City of Portland, Maine - Building or Use Permit Application

Permit No: 02-0153	Issue Date: MAR - 8 2002	CBI: 186A A018001
-----------------------	------------------------------------	----------------------

Location of Construction: 110 Whitney Ave	Owner Name: Jones James Robert &	Owner Address: 110 Whitney Ave CITY OF PORTLAND	Phone: 775-5051
--	-------------------------------------	--	--------------------

Proposed Project Description: Build 40' x 22' kennel and 38' x 20'8" shop
--

DAVE WINE CONSTRUCTION, INC.	
Sub: 11-54611	Quantity: _____
Dist: 1-25-02 FOUNDATION	Drawn By: JC
Drawn By: JONES	Checked: _____
Location: BOATLAND W/B	Project #: _____

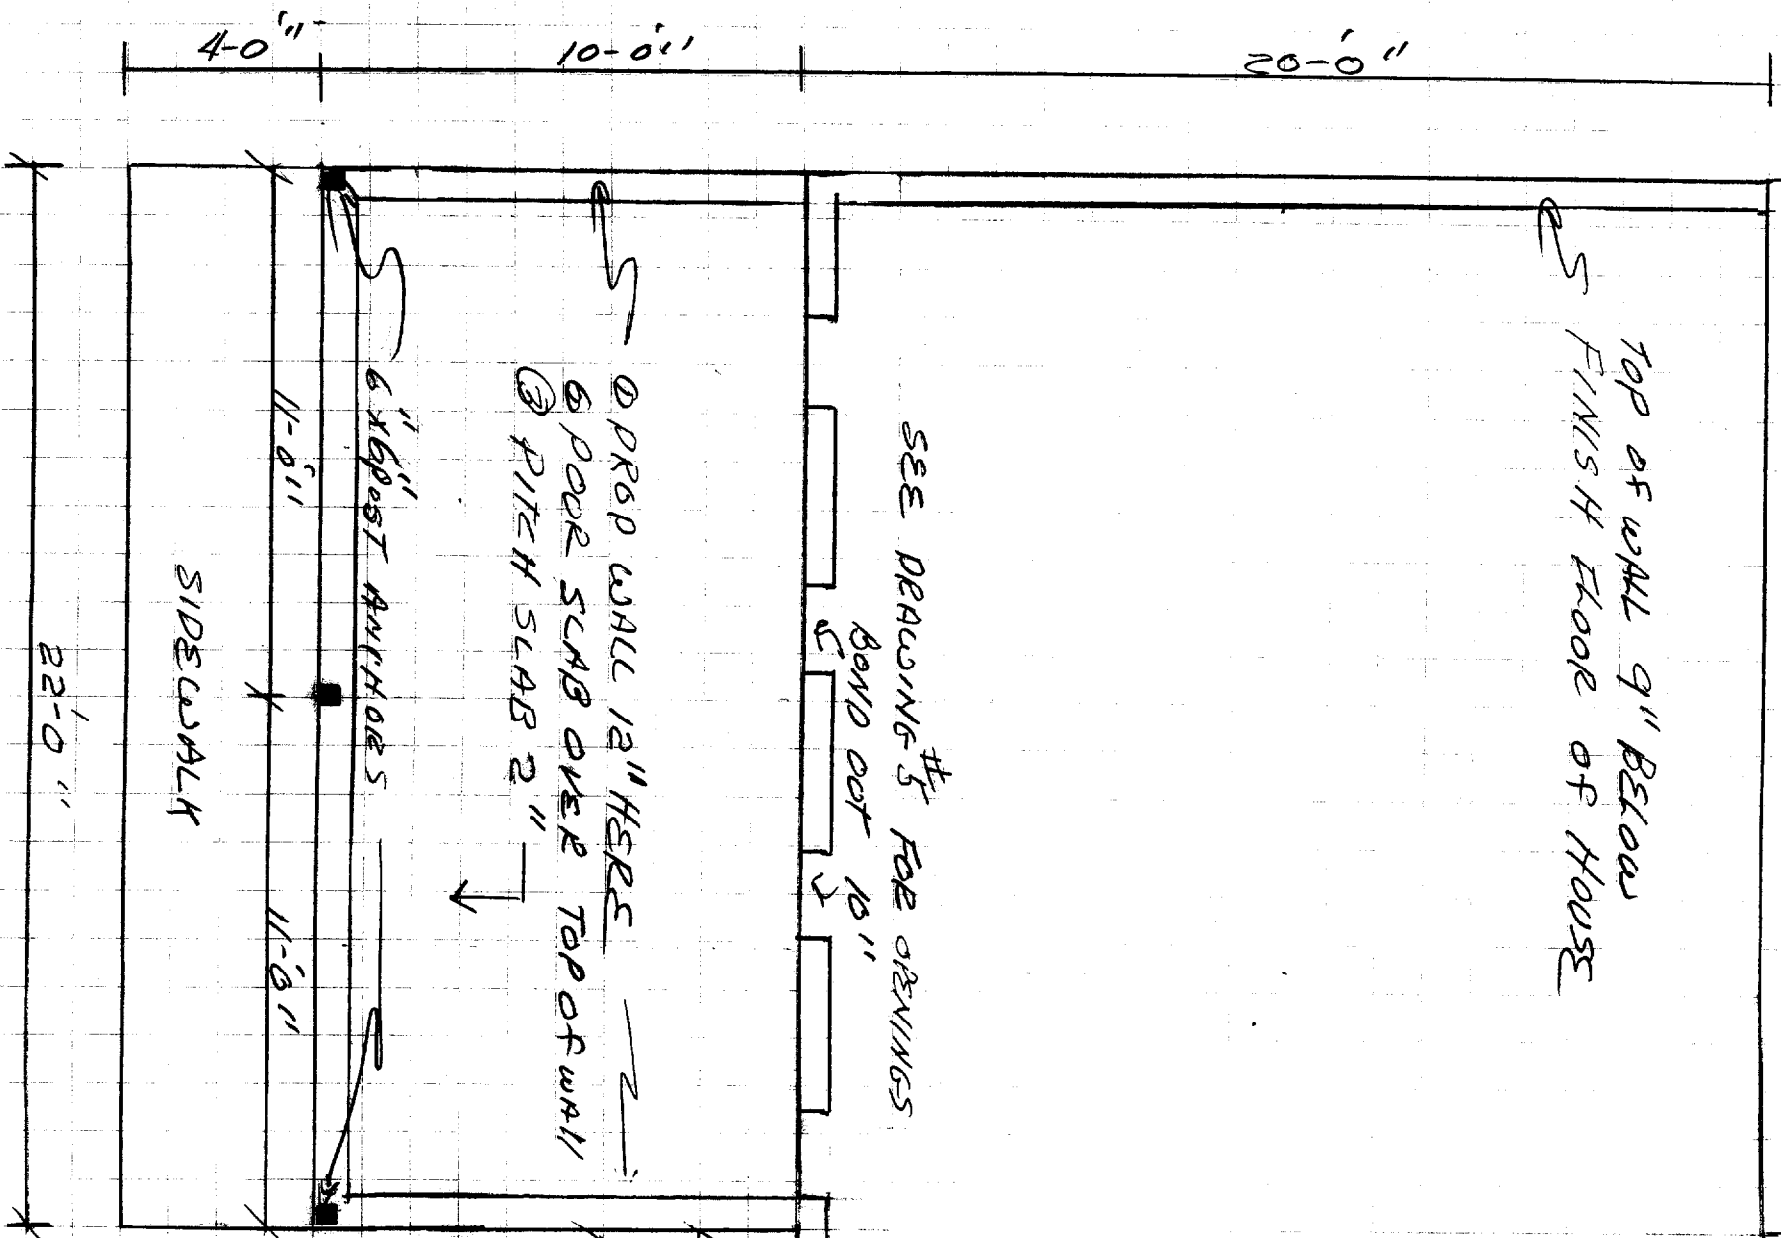
- 
1. Footing Dimensions
 2. Foundation wall thickness Foundation cross section
 3. Size of anchor bolts
 4. The 6" x 10" headers in the "open roof system" are under designed (See Table 502.5(1) in the 2000 I.R.C.
 5. Step details from existing house
 6. Header details where omitted
 7. Egress window replacement schedule in existing house (Hardware included)
 8. Electrical detail
 9. Plumbing plan for "both rooms"
 10. Foundation Drilling and Pinning detail
 11. Steps stairs and landing details for the exterior doors.
 12. Demo Permit Must be obtained prior to issuance of this permit due to lot coverage
